**KIRKLEES METROPOLITAN COUNCIL
INVESTMENT & REGENERATION SERVICE**

DELEGATED DECISION TO DETERMINE PLANNING APPLICATIONS

Reference No:	2024/62/90773/W
Site Address:	82, Banks Road, Linthwaite, Huddersfield, HD7 5LP
Description:	Demolition of existing conservatory and dormer and erection of replacement side extension and dormer with raised platform and associated alterations
Recommending Officer:	Molly Storer

DECISION – CONDITIONAL FULL PERMISSION

Proposed First Floor Plan

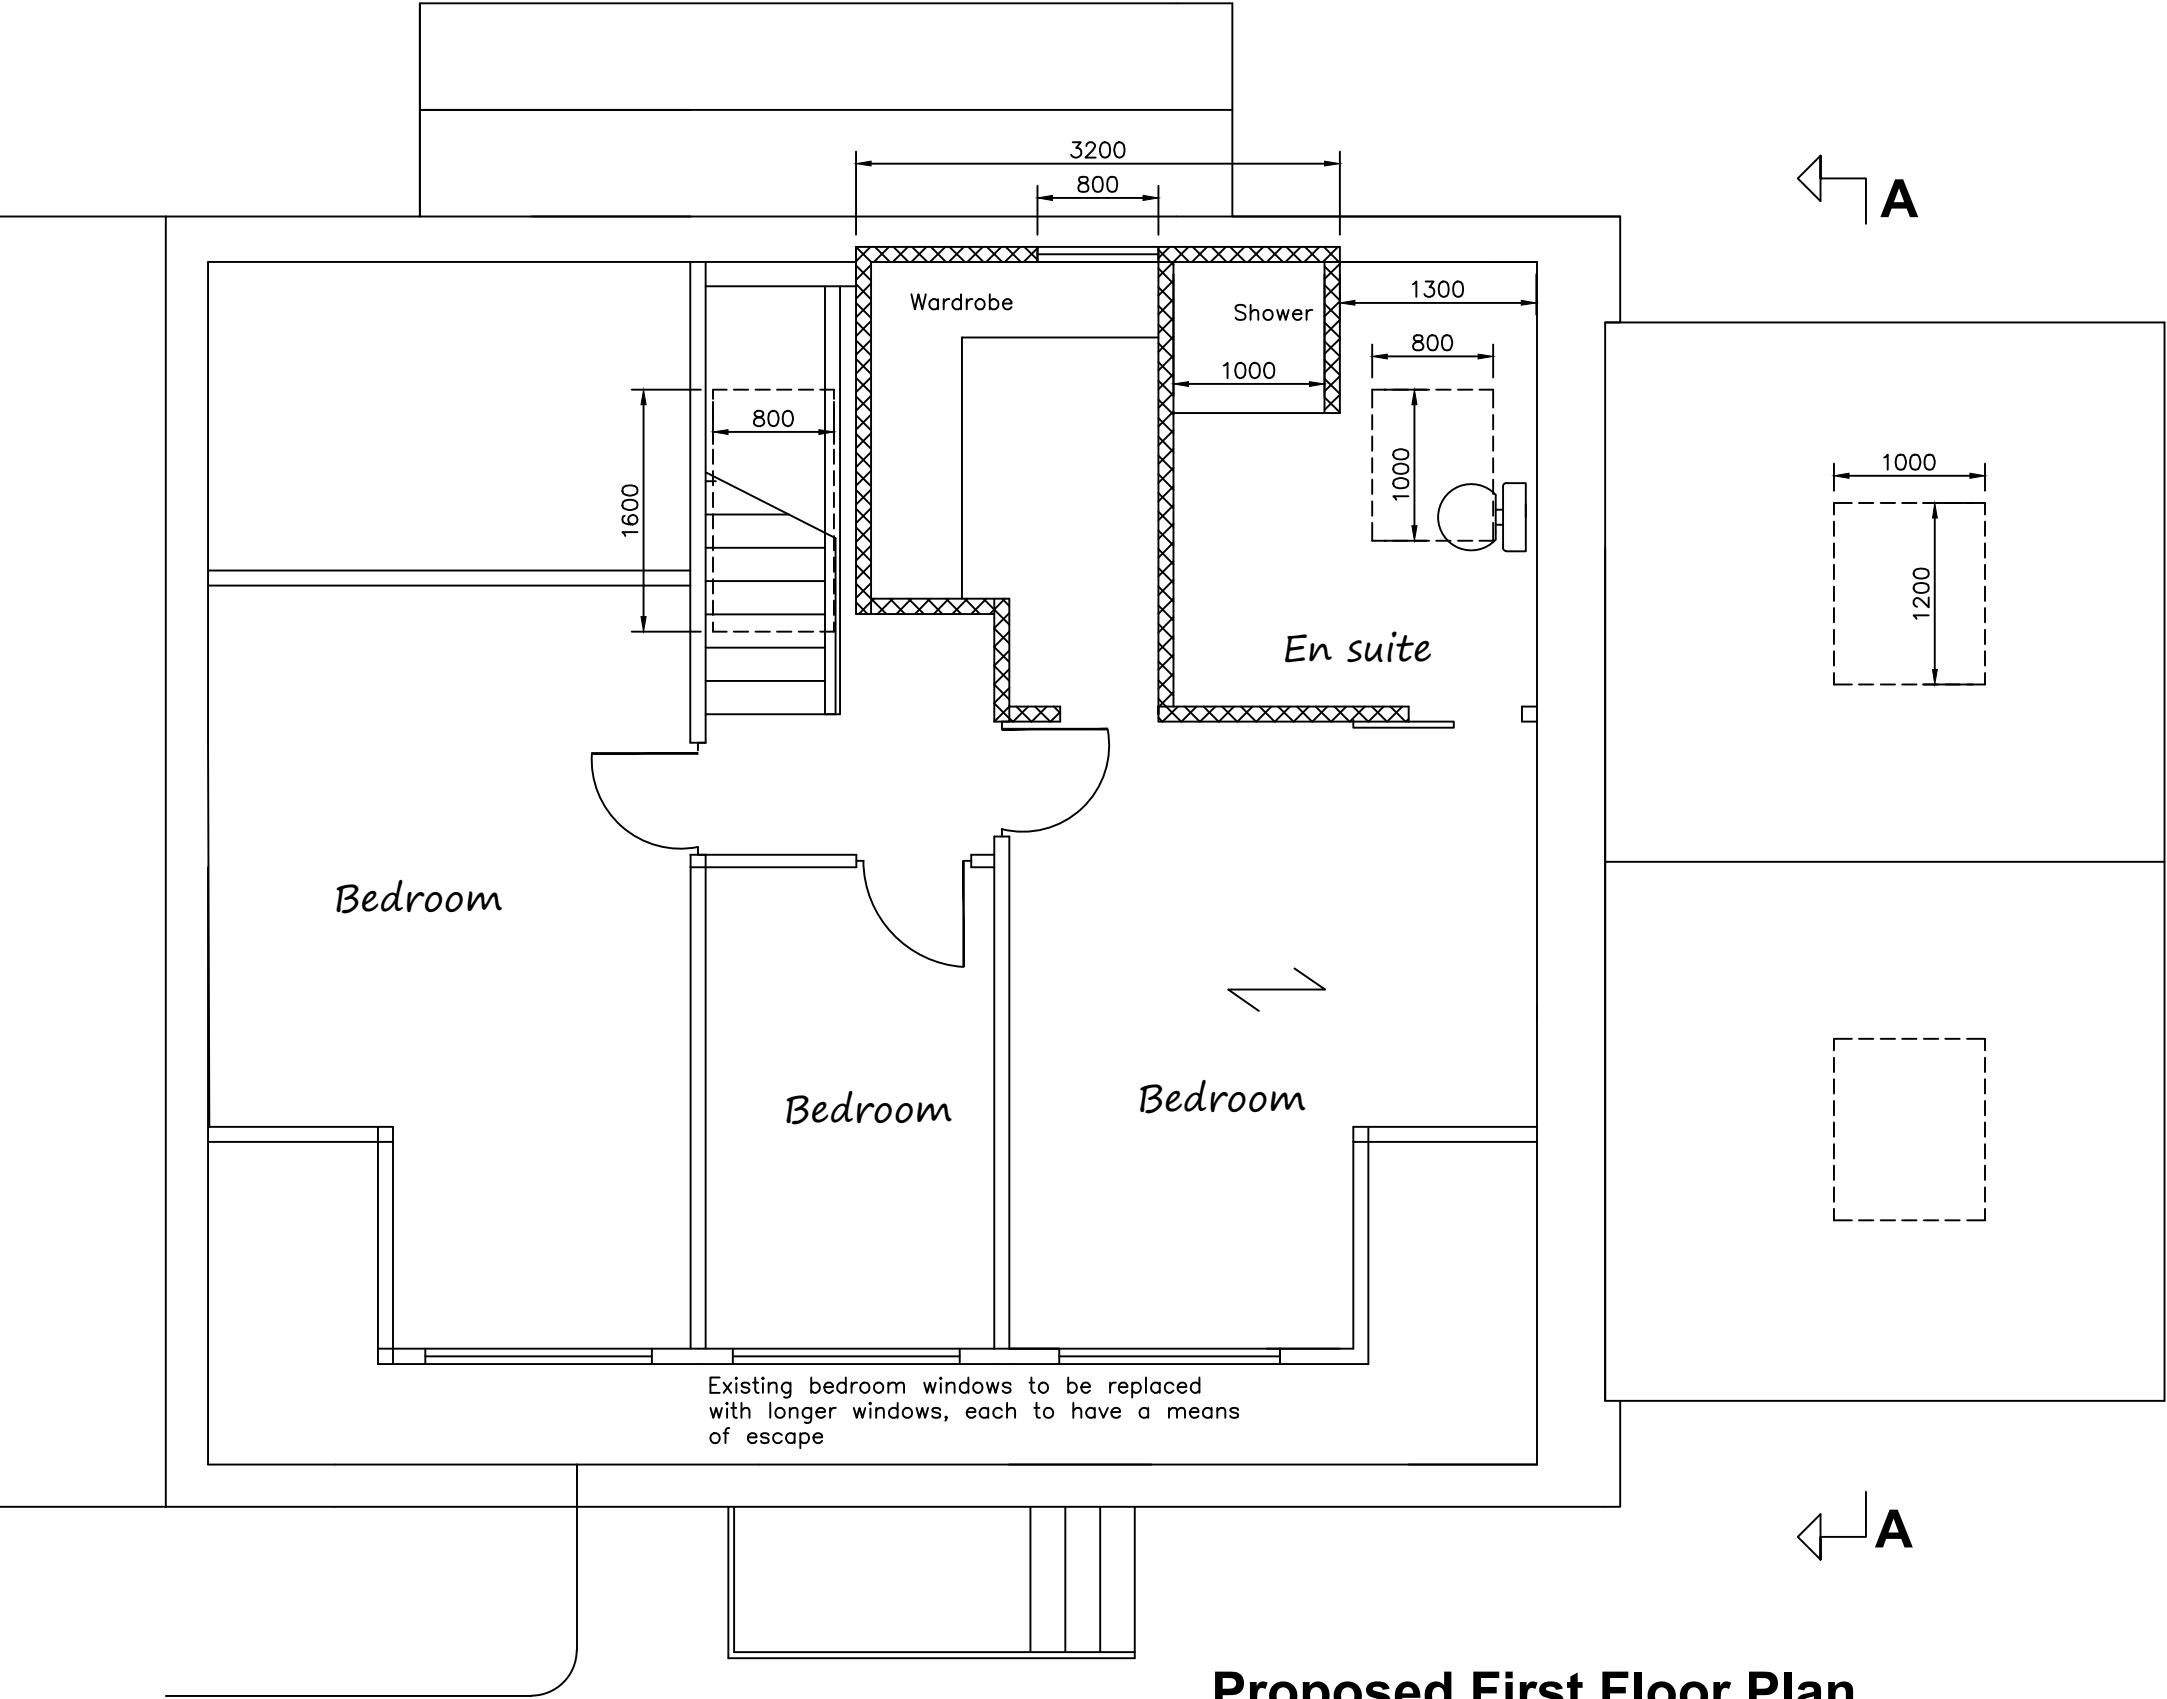
This dormer will replace an existing dormer on the same elevation. It will project 1.3m from the roof slope, have a width of 3.2m and an overall height of 3.5m. The dormer will have a lean-to roof form and will be set down from the original roof ridge by 0.9m. this will create space for a bigger master bedroom and ensuite.

Proposed East Elevation

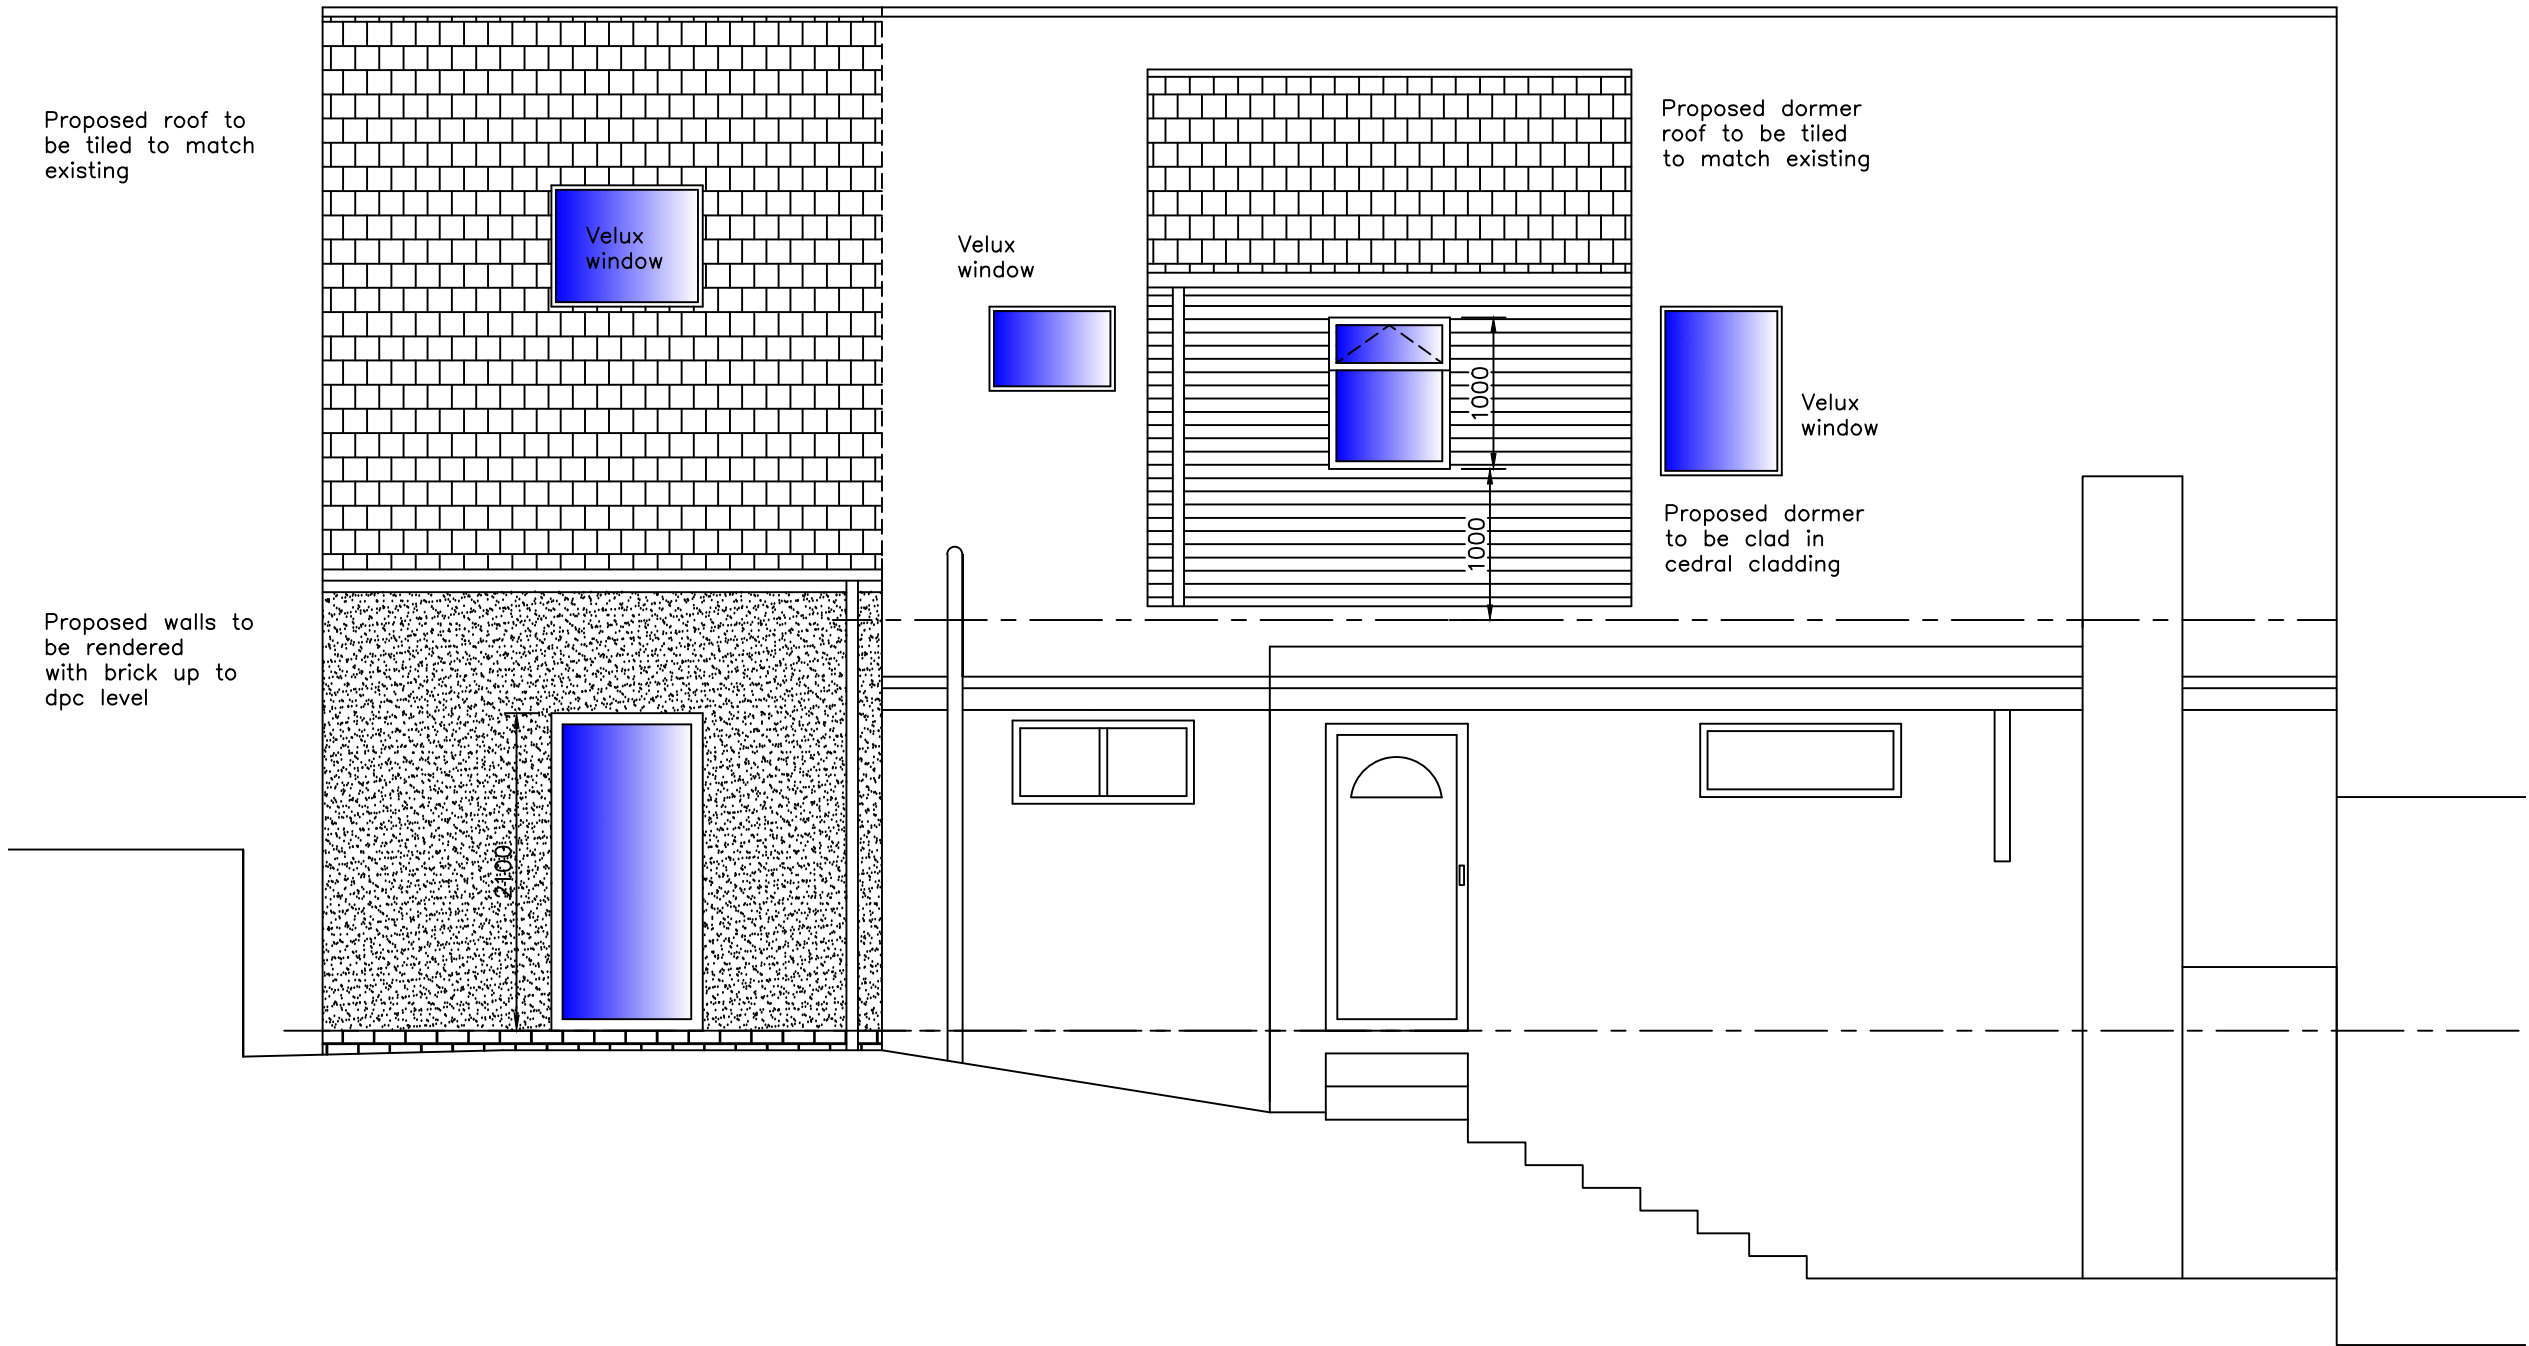
- Two new single windows either side of the proposed dormer on the east elevation

These minor alterations are considered acceptable as due to the orientation of the houses and dense vegetation the additional glazing will be naturally screened. The change of materials on the dormer is considered to be sympathetic as it will match that of the proposed dormer.

Dormer

Dormer extensions should:	<u>Yes - COMPLY</u>	<u>No - JUSTIFY</u>
relate to the appearance of the house and existing roof	The dormer will replace an existing dormer of a similar size and will be set well within the confines of the existing roof.	
be designed in style and materials similar to the appearance of the existing house and roof	The dormer will be constructed from Cedral cladding to match that of the dormer on the opposite elevation and the roof will be tiled to match the existing property.	
not dominate the roof or project above the ridge of the house	Due not the limited projection and width the dormer will be a subservient addition and will not dominate the roof of the existing dwelling.	
be set below the ridgeline of the existing roof and within the roof plane	The dormer will be set below the ridgeline of the exiting roof by 0.9m.

4. The dormer hereby approved shall be clad in a dark grey colour finish which shall be retained thereafter.

Proposed West Elevation

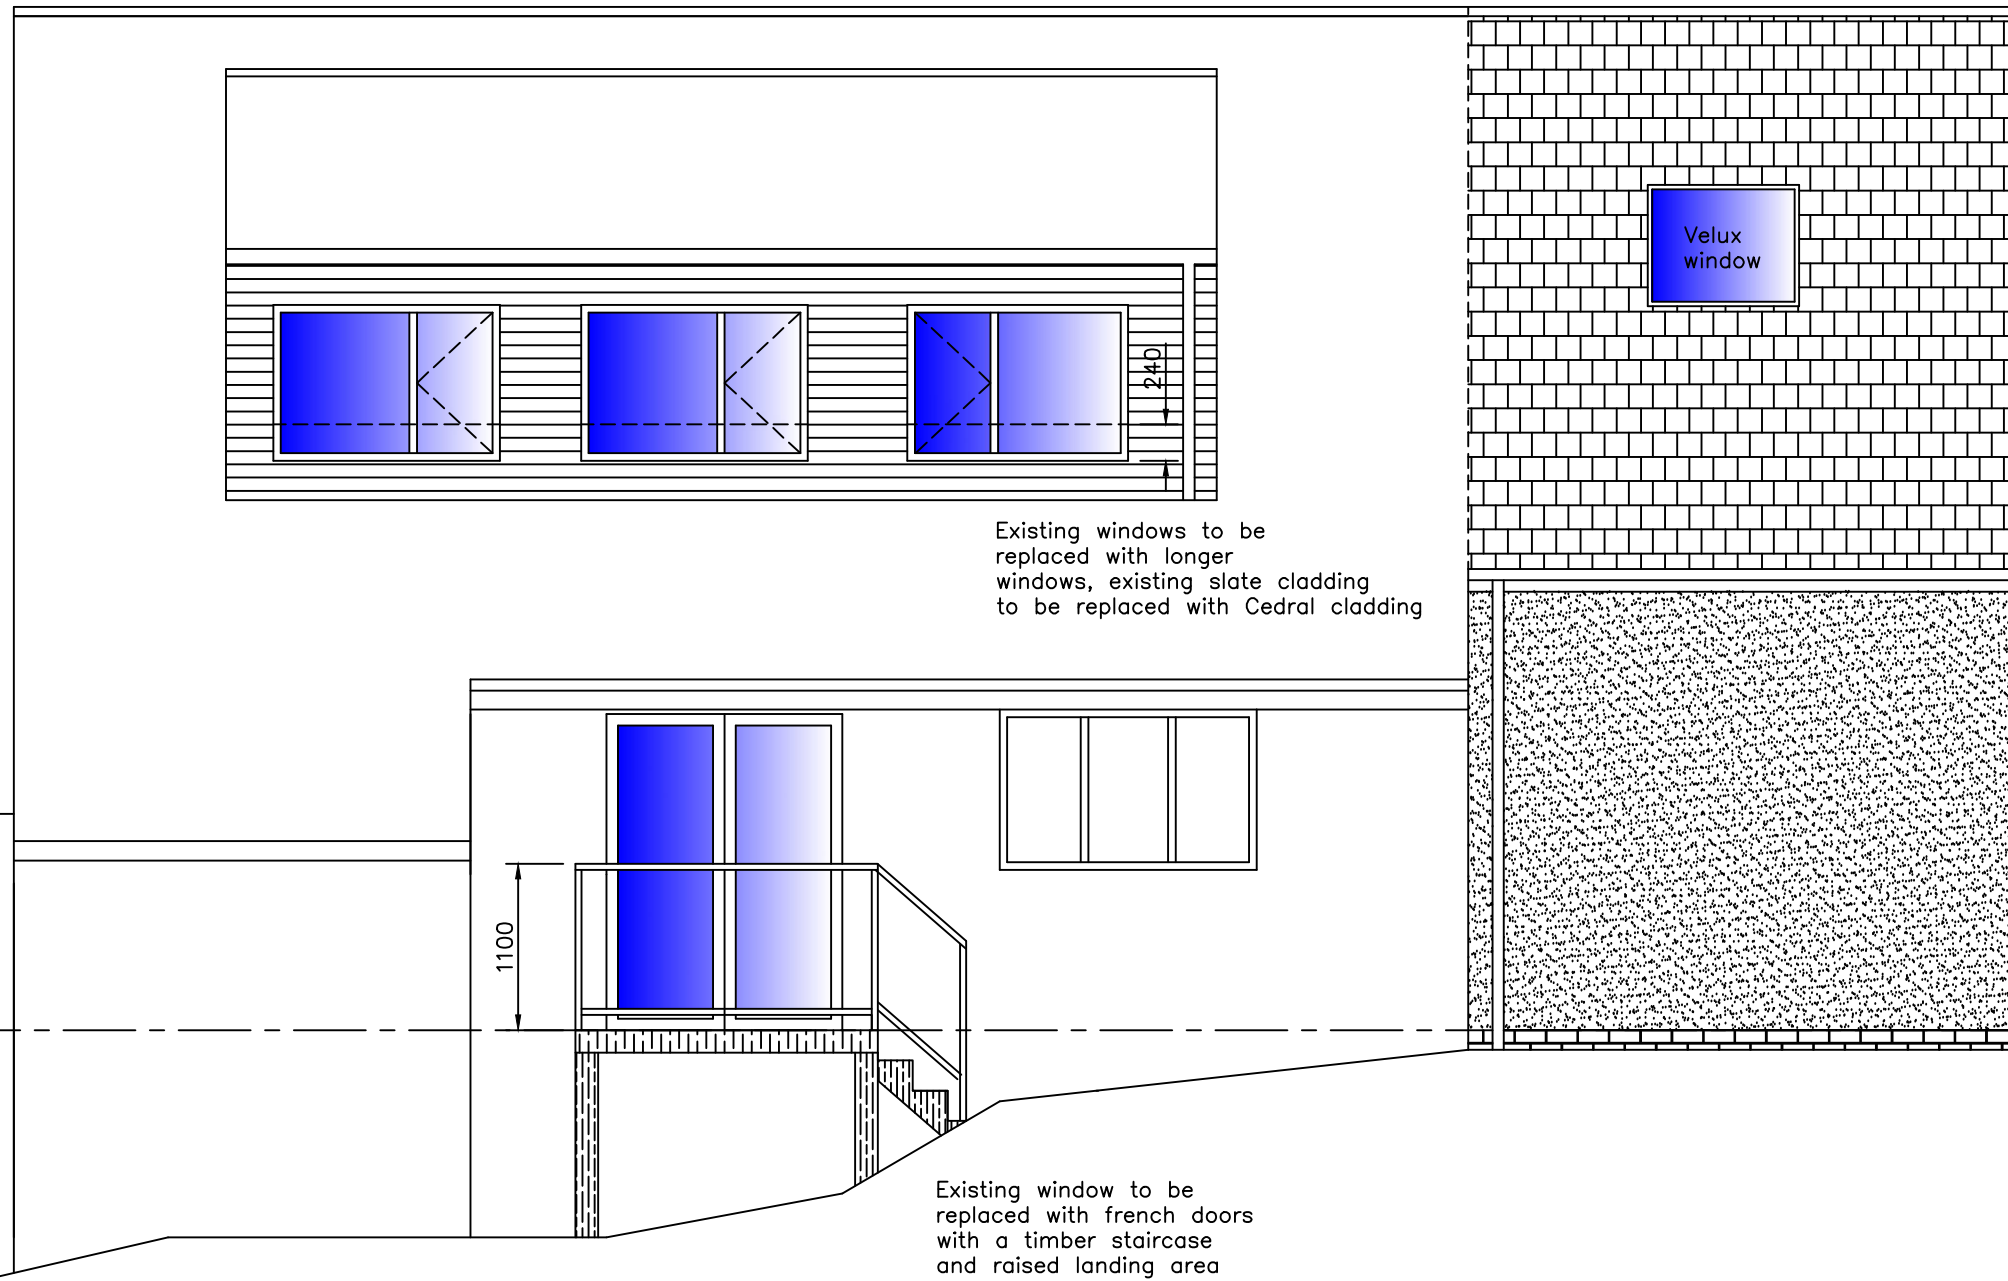
Raised platform

The raised platform will be located to the west elevation. The existing window in this elevation is proposed to be replaced with French doors accessed via a timber staircase and raised landing area. This will measure 1m x 2m and will be raised off the ground by 1.9m. Due to the location of the platform 22m from the road, it being at a significantly lower land level and the limited scale of this element it is considered that it would not be significantly visible from public viewpoints and would not disrupt the street scene. Due to the dense vegetation on site and large separation distances to surrounding properties it is considered it will not cause any significant harm to neighbouring properties.

- existing windows to be replaced with slightly larger windows on the west elevation dormer and slate cladding to be replaced with Cedar cladding.
